**Application Reference:** 2025/0726

**Site Address:** Colmarlee, 2A Lee Lane, Royston, Barnsley, S71

**Introduction:** Erection of a single storey side extension

PLAAN & ELEVATIONS

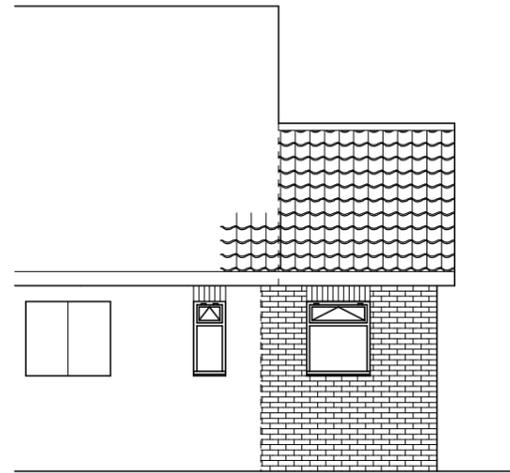
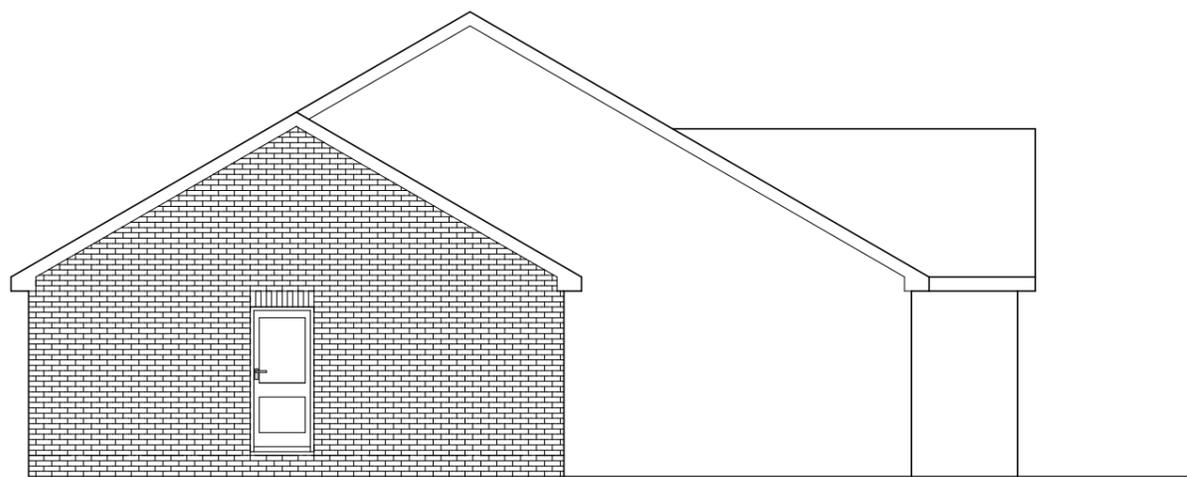
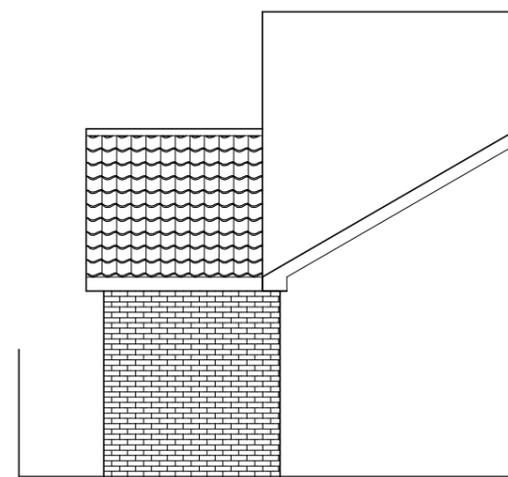
The proposed side extension provides a pitched roof, replicant of the existing roof form. This allows the proposal to remain in keeping with the dwelling. A modest sideways projection is proposed and retains a distance of approximately 1.2 metres to the boundary. This allows for access to the rear of the property and garage to be maintained. It is noted no window has been detailed to the front elevation of the proposal, however, given the proposal is a minor projection and an extension could be proposed in the same location under permitted development, the blank elevation on this occasion is considered acceptable. The Proposal is

set down from the ridge and is set back from the front elevation by approximately 4.9 metres allowing the proposal to remain subordinate to the existing dwelling. The use of matching materials is welcomed and ensures the proposal remains in keeping with the site.

The proposal is to the north of 2 and 2B Lee Lane and will therefore not impact loss of sunlight. It is acknowledged that the separation distance would fall below the 12m set out in the SPD between rear habitable rooms windows and a side elevation, however, the proposal is substantially screened by boundary treatment and is set away from the boundary by approximately 1.2 metres. This allows for the avoidance of any dominance from the proposal and prevents any loss of privacy. In addition, there are no side windows detailed to the proposal. A door is proposed however this is substantially screened by boundary treatment and services a hallway.

The proposal would not result in the addition of any bedroom facility however would result in the loss of some potential parking facility. Use of the garage as a parking facility would be lost due to the siting of the proposal, however parking facility for two cars will be retained on the existing driveway.

It has been necessary to make contact with the agent in order to amend the proposed projection. The original projection was considered too large and would have provided a poor precedent within the street scene and detracted from the character of the dwelling. Amendments were received on 25<sup>th</sup> September 2025, reducing the projection.
